# V1Grading and Erosion Control Plan.pdf Markup Summary

PROJECT #: 221206
 SHEET NUMBER
6
 6 OF 14

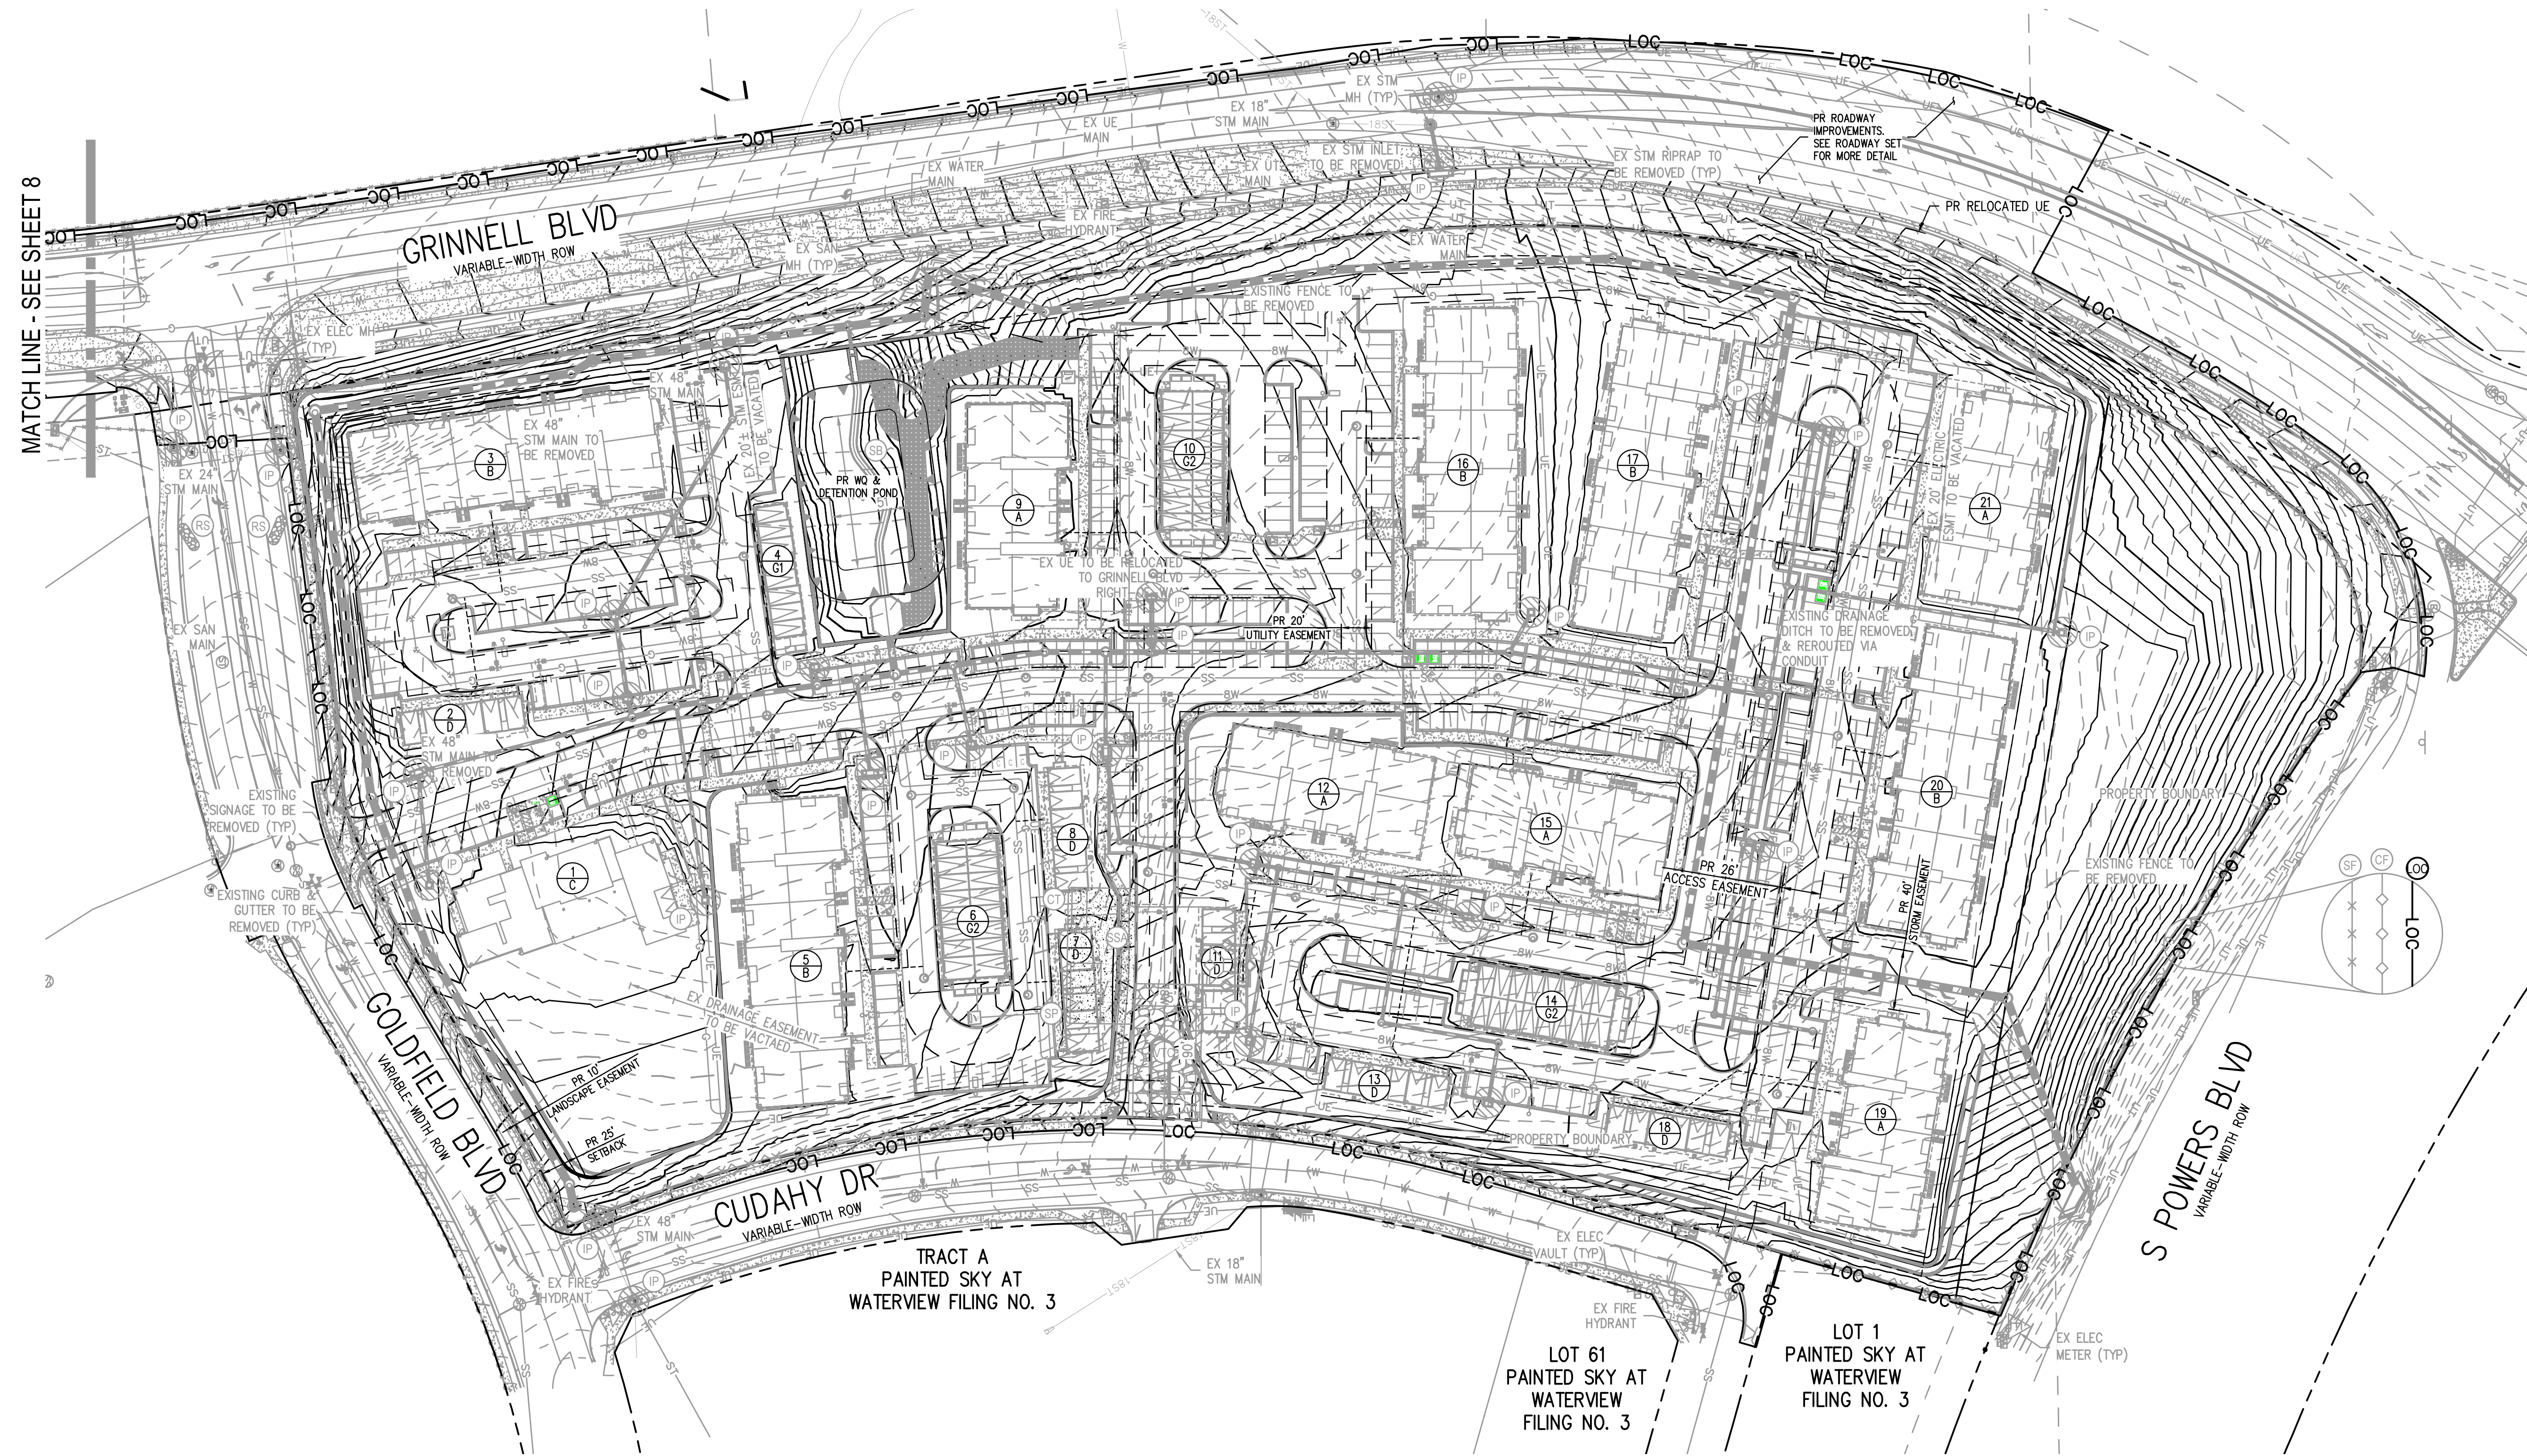
Per legend, this is stabilized staging area? I believe this is new pavement for the widening of Grinnell. Please revise legend or hatching on the plan to be different.

OUTLOOK POWERS & GRINNELL
 GESC - FINAL

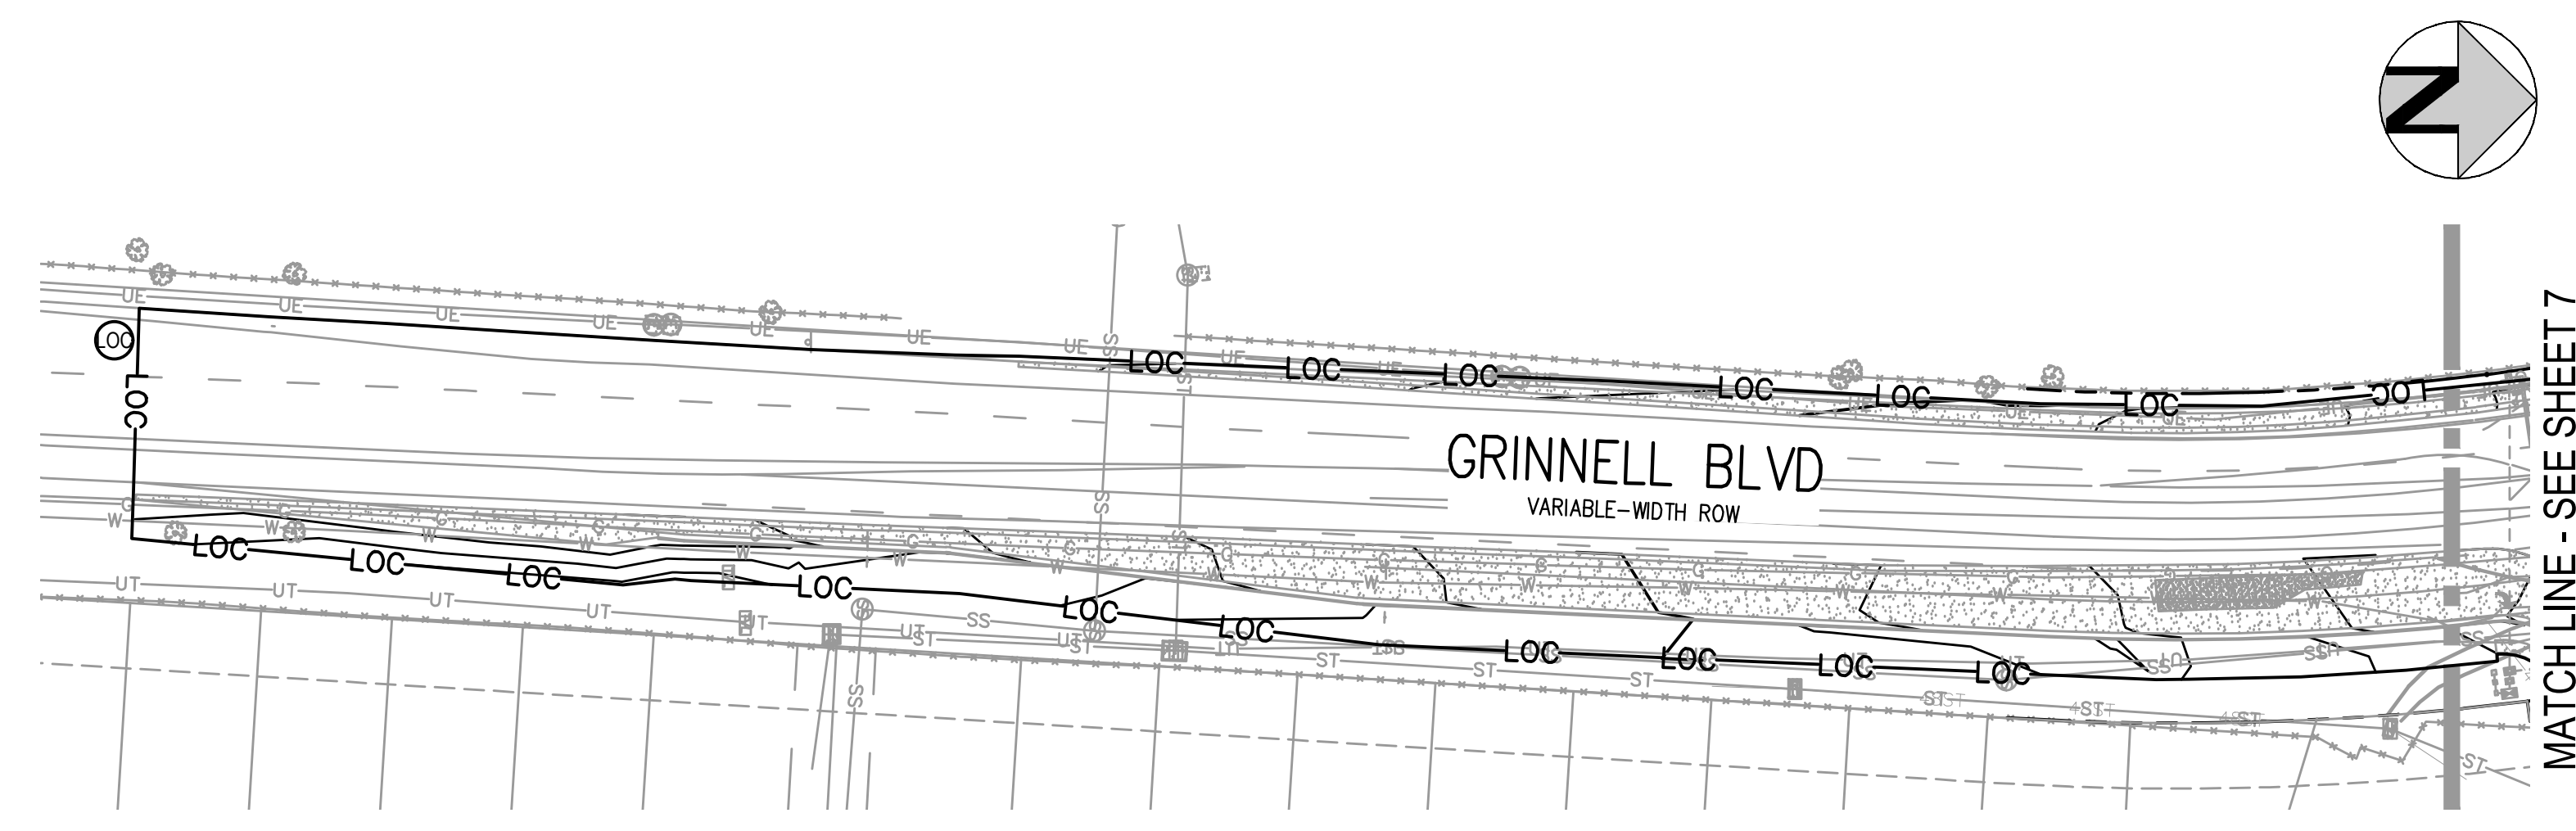
Provide contour labels

Show areas of seeding/mulching on the final phase plans.

Typical comment: Show all swales and grading as well as provide details for the swale underdrains, their tie-into the storm sewer, and the swale typical section

Drainage Report shows a swale here and the swale calcs call for an underdrain - provide grading contours, a typical section, and show the underdrain and how it ties into the storm sewer.

Drainage Report shows a swale here and the swale calcs call for an underdrain - provide grading contours and a typical section.
